Permit Number: 021297

has permission to Erect 291 sq. Ft. Sign

AT 615 Warren Ave 314 A003001

615 Warren Ave -
11/21/02 Free standing sign is showing over 100 sq. Feet -
talked to Mark Sengleman - he will revise & fax me
11/22/02 Mark requested that the permit be amended to
omit the freestanding sign at this time while the prints are

PYLON SIGNAGE  
MODEL WP100  
w/Tenant  
Cabinet

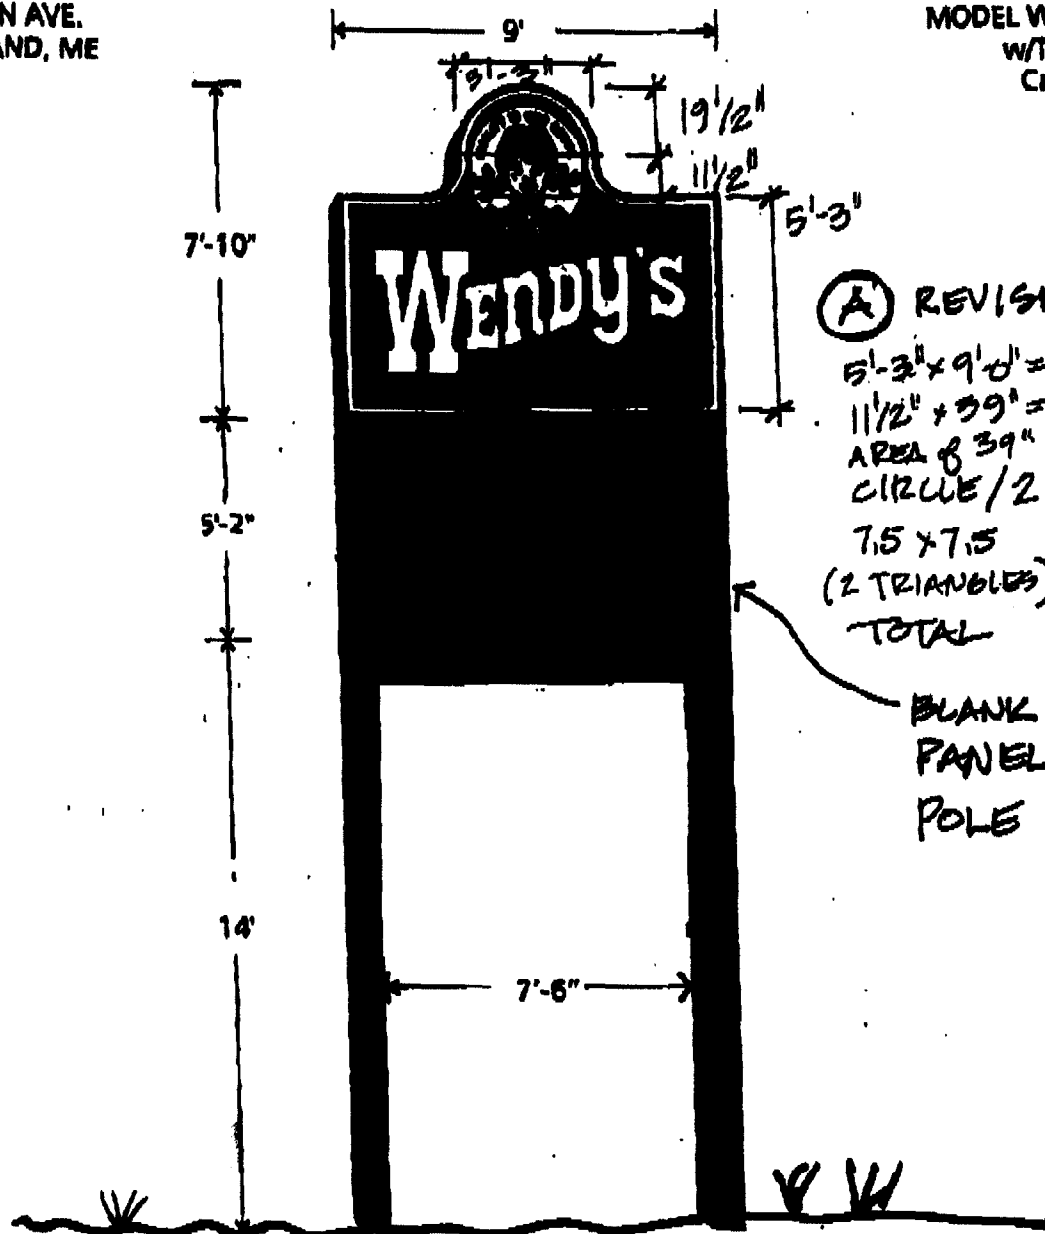
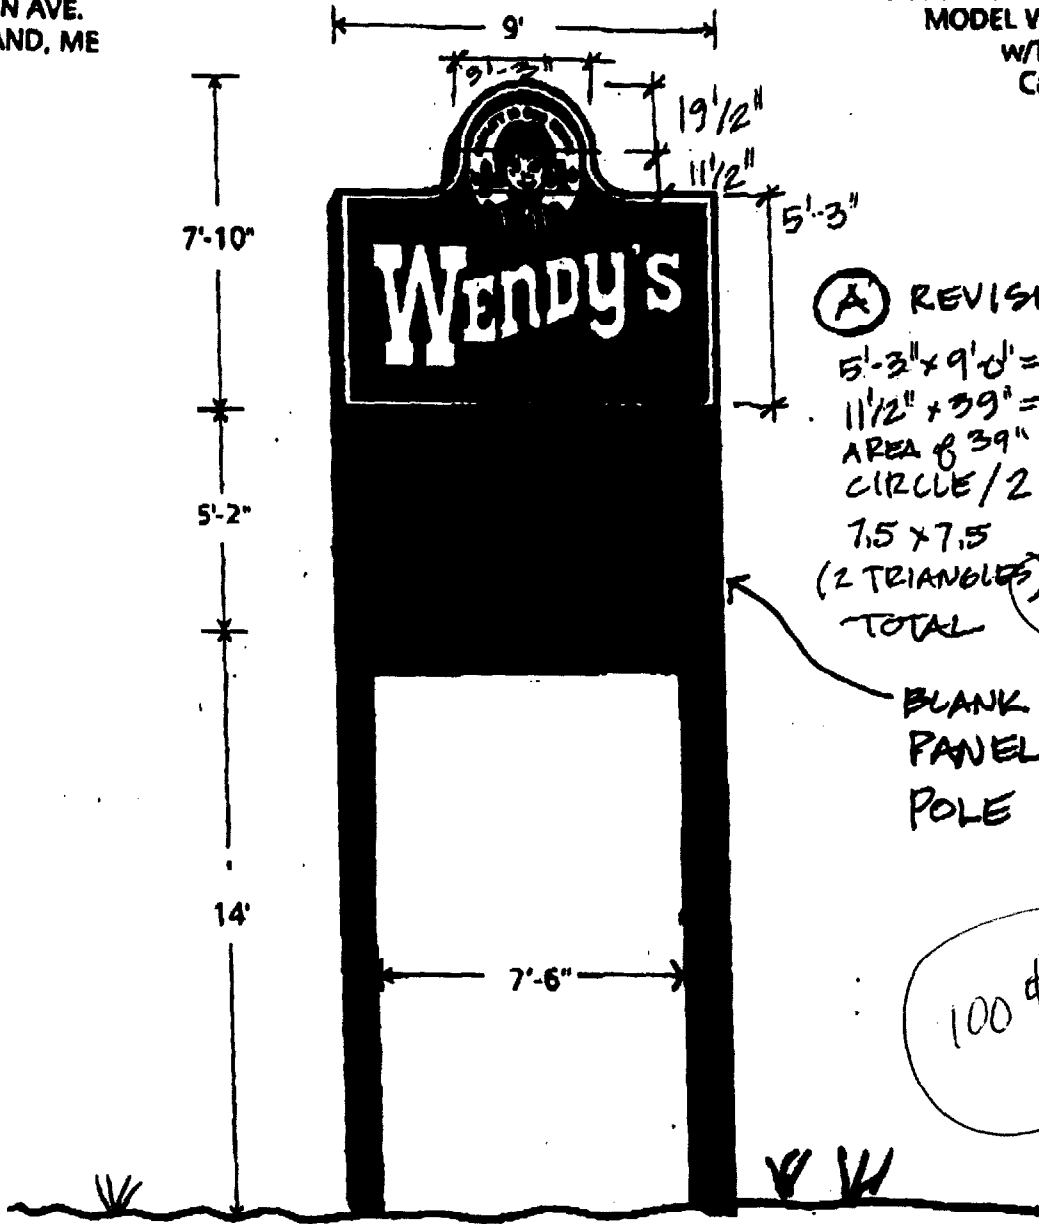
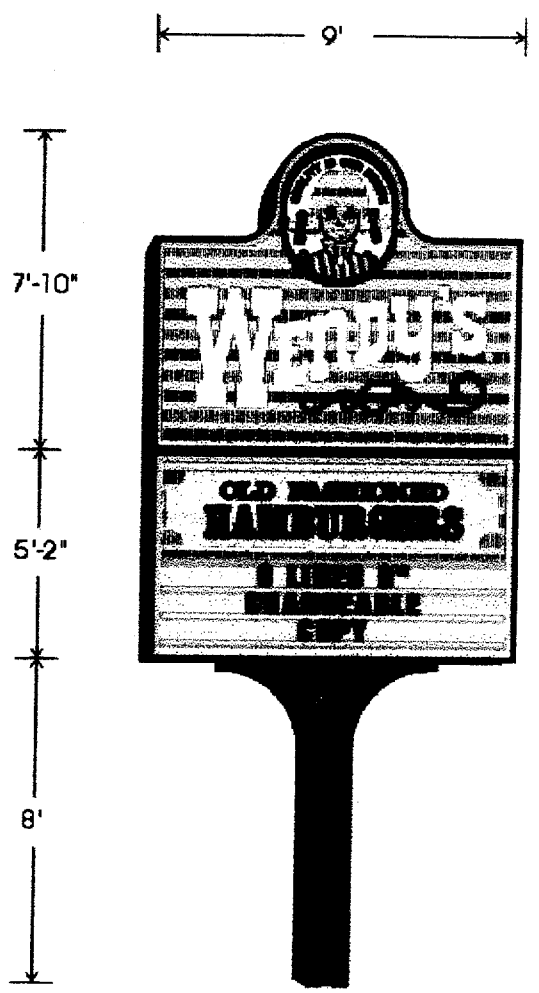
Free Standing Sign
≥ 200' Street frontage
(263.92' shown)
MAX Area: 100 # - revised to exactly 100 # for all
height: 35' - 27' shown
Setback: 5' from property lines - 5' shown

This permit approval encompasses the building signs and directional signs and sandwich board drive-thru signage. This approval does not include the free standing sign. The approval for a free standing sign has also been approved based upon the plan relayed by Thaddaus King on 11/22/02.

Proposed Project Description: Erect 291 sq. Ft. Sign	<p><i>11/27/02 - permit revised for Bldg signs only - not the freestanding sign (that will be revised & amended later) - 11/28/02 permit revised drawings for free standing sign - ok</i></p>	FIRE DEPT: <input type="checkbox"/> Approved <input type="checkbox"/> Denied	INSPECTION Use Group: <i>A/U</i> Type: <i>NA</i> <i>11/25/02</i>
		Signature:	Signature: <i>[Signature]</i>
PEDESTRIAN ACTIVITIES DISTRICT (P.A.D.)		Action: <input type="checkbox"/> Approved <input type="checkbox"/> Approved w/Conditions <input type="checkbox"/> Denied	Signature: _____ Date: _____
